Jean Fraser - 421 Warren Avenue

From: Tom Errico <thomas.errico@tylin.com>
To: Jean Fraser <JF@portlandmaine.gov>
Date: 5/22/2014 12:08 PM
Subject: 421 Warren Avenue
CC: David Margolis-Pineo <DMP@portlandmaine.gov>, Katherine Earley <KAS@port...

Jean – The following represents my final comments and are presented as a status update of my March 12, 2014 preliminary comments.

WB-67 AASHTO 2011 (US)

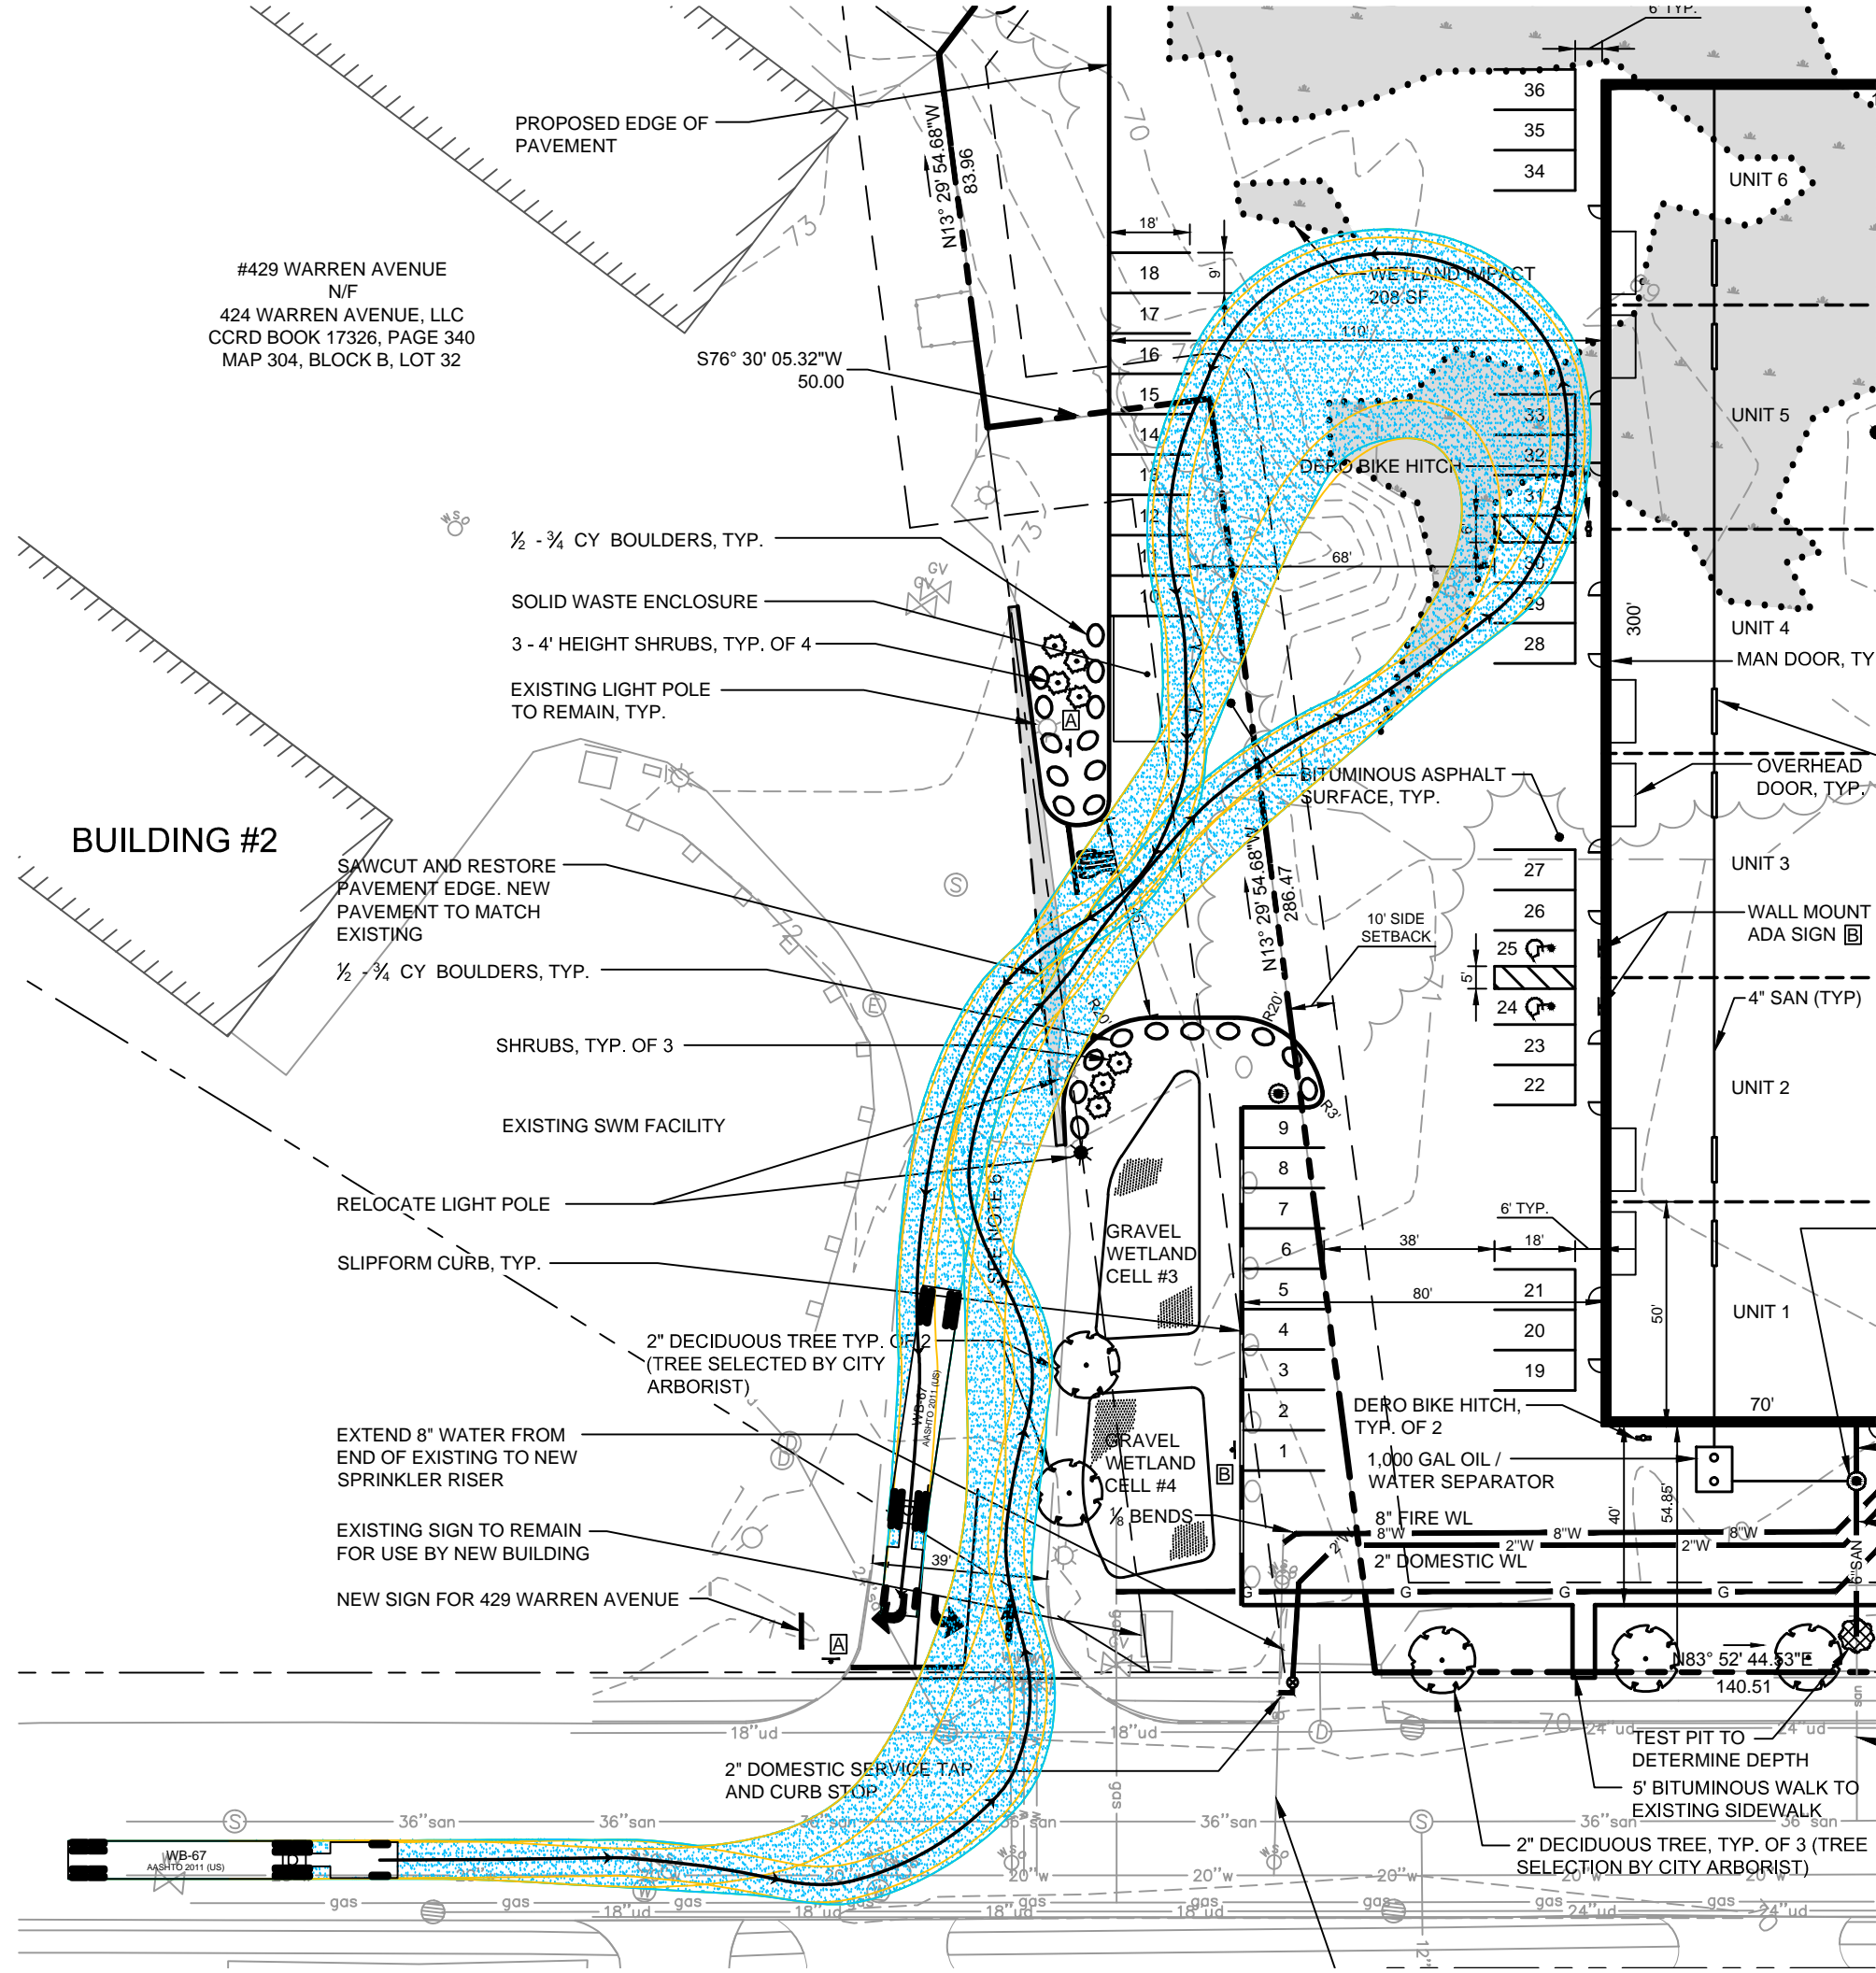
- The aisle widths in the internal parking/circulation area do not meet City standards and a waiver will be required. The applicant shall provide an Auto-Turn analysis documenting the need for the expanded pavement areas.

- **The applicant has provided a truck turning template graphic that shows a significant portion of the parking lot will be required for very large truck maneuvers. The graphic also illustrates that the trucks will require use of areas that are noted as general passenger car parking spaces. From a traffic perspective the paved area will not present safety or circulation problems. The applicant will need to coordinate closely with tenants to ensure parking areas will not constrain large truck maneuvers. It is my understanding that the applicant has experience managing this type of situation. Given that the site is somewhat contained and is set back from Warren Avenue, I find conditions to be acceptable and support a waiver for parking lot aisle width.**

Drawing file: PLANS / C-3.0 Site Layout and Utility Plan.pdf

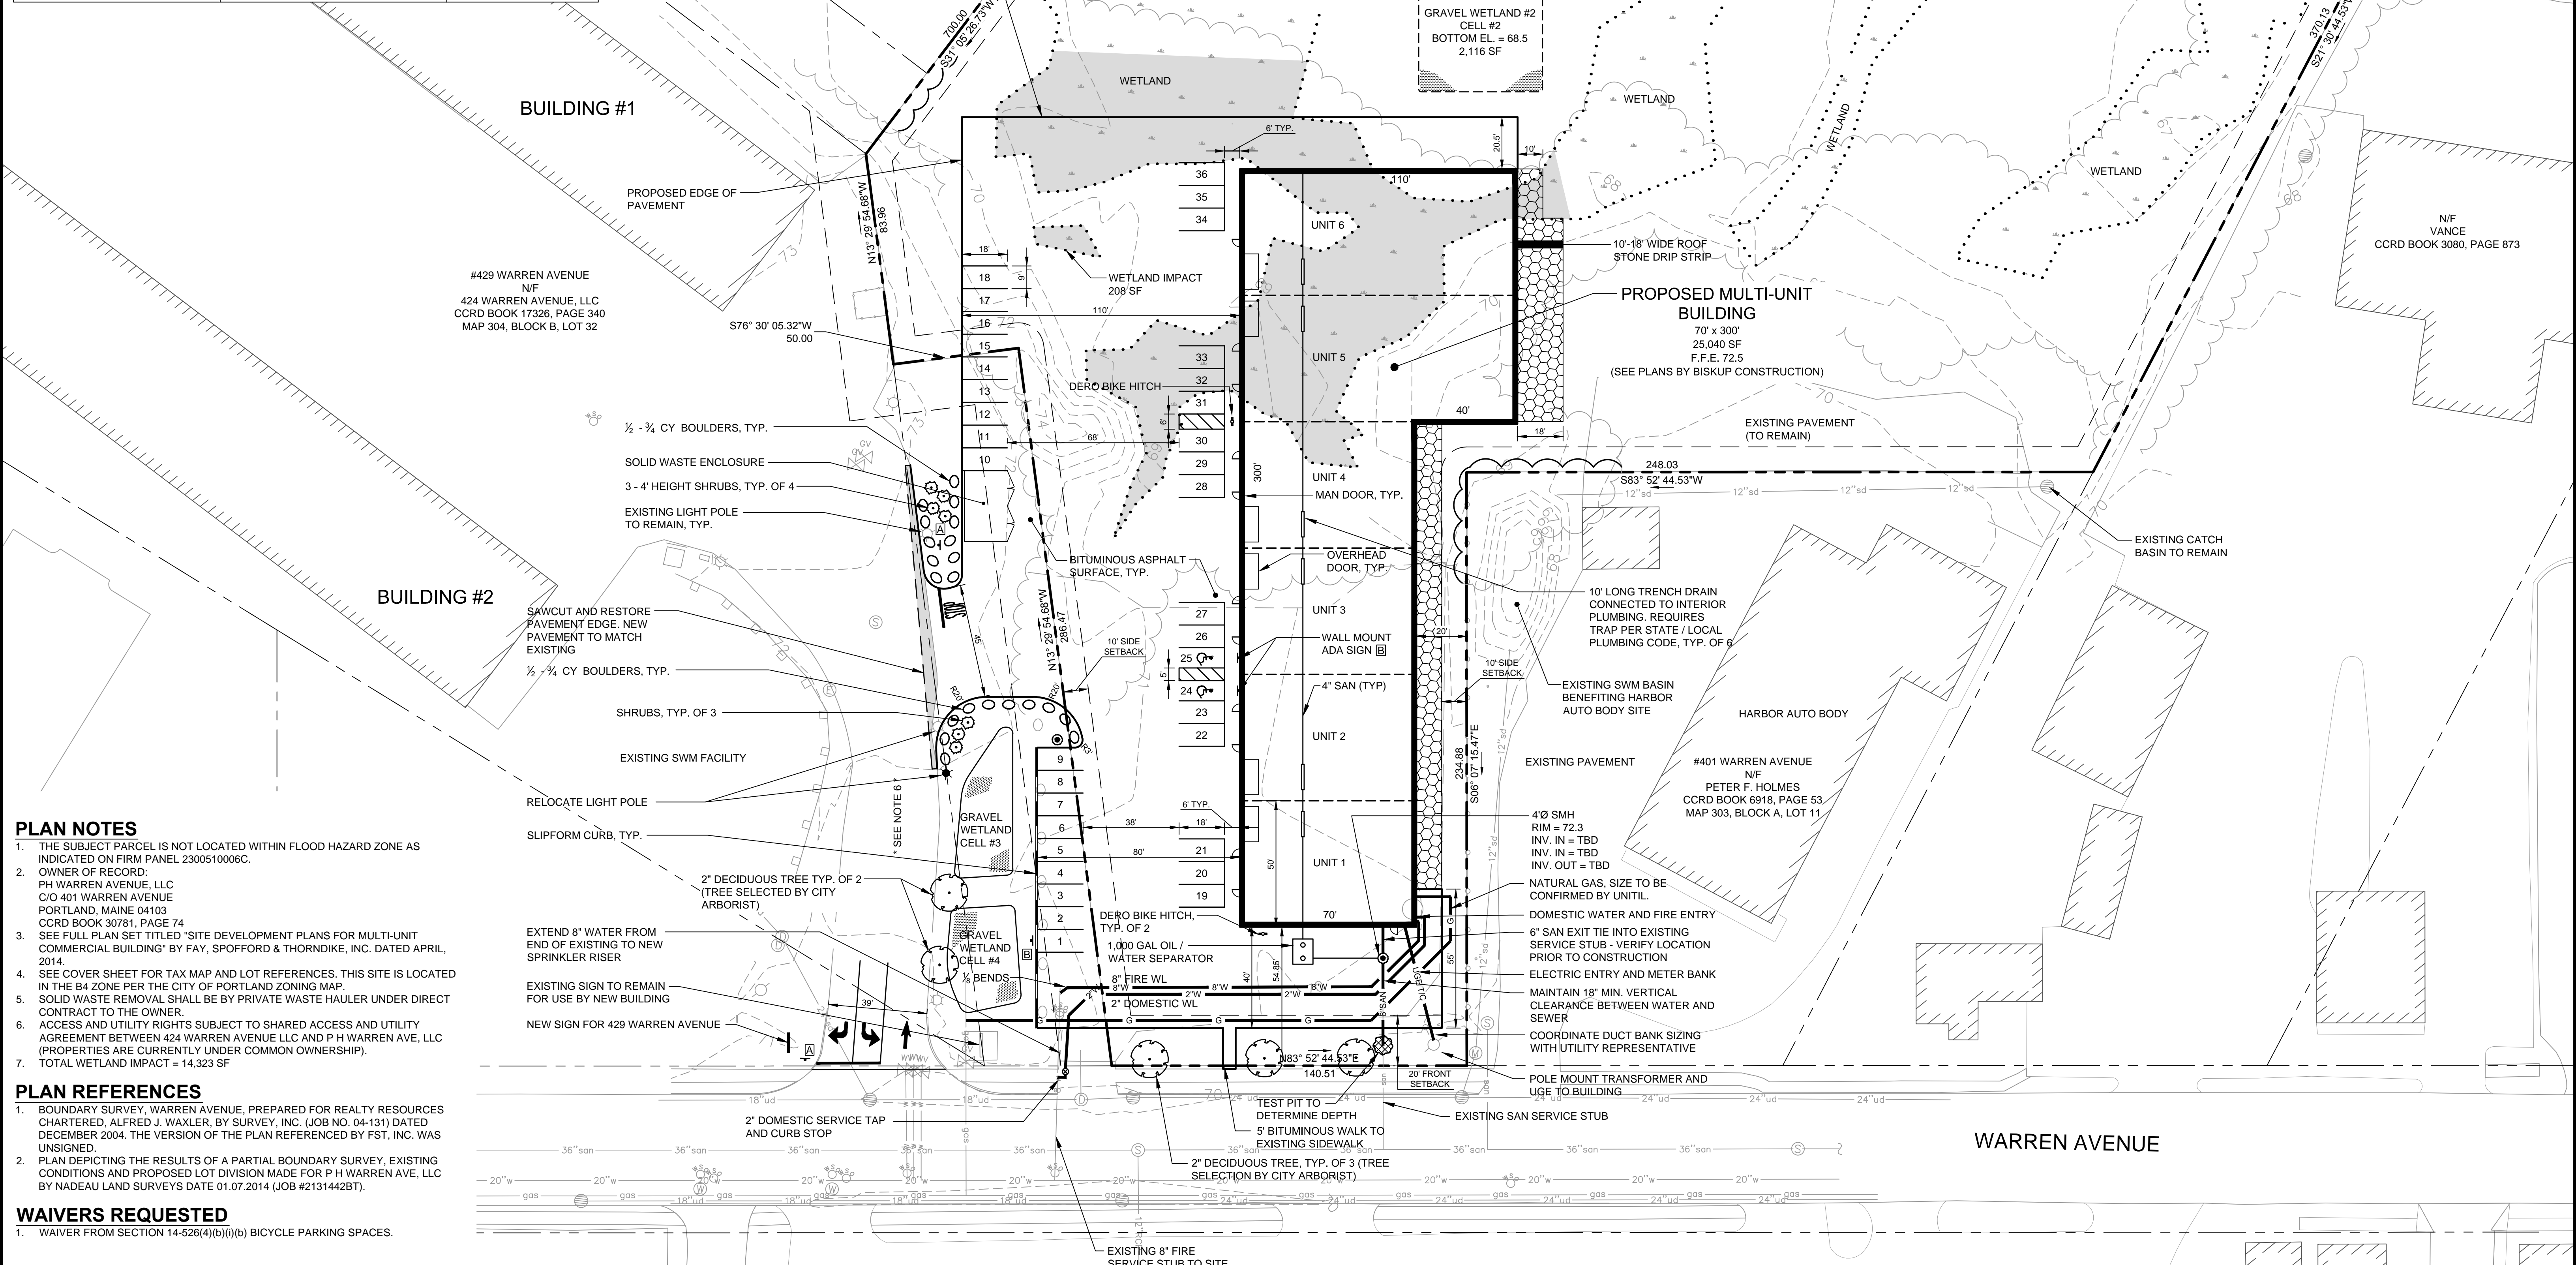
- The proposed driveway entrance exceeds City standards and a waiver will be required. The applicant shall provide an Auto-Turn analysis documenting the need for the wide driveway.

- A sidewalk connection from the proposed building to Warren Avenue shall be provided.
 - **The site plan has been revised to include this and therefore I have no further comment.**

- An area along the building frontage on the parking area shall be marked such that pedestrians have a direct routing to Warren Avenue.
 - **The plans should be revised to include this painted area.**

- **Status - In response to this comment, the applicant has reduced the size of the driveway. The revised driveway width continues to exceed the City's standard. Based upon a review of a truck turning template graphic, I find the proposed driveway design to be acceptable and therefore I support a waiver from City standards.**
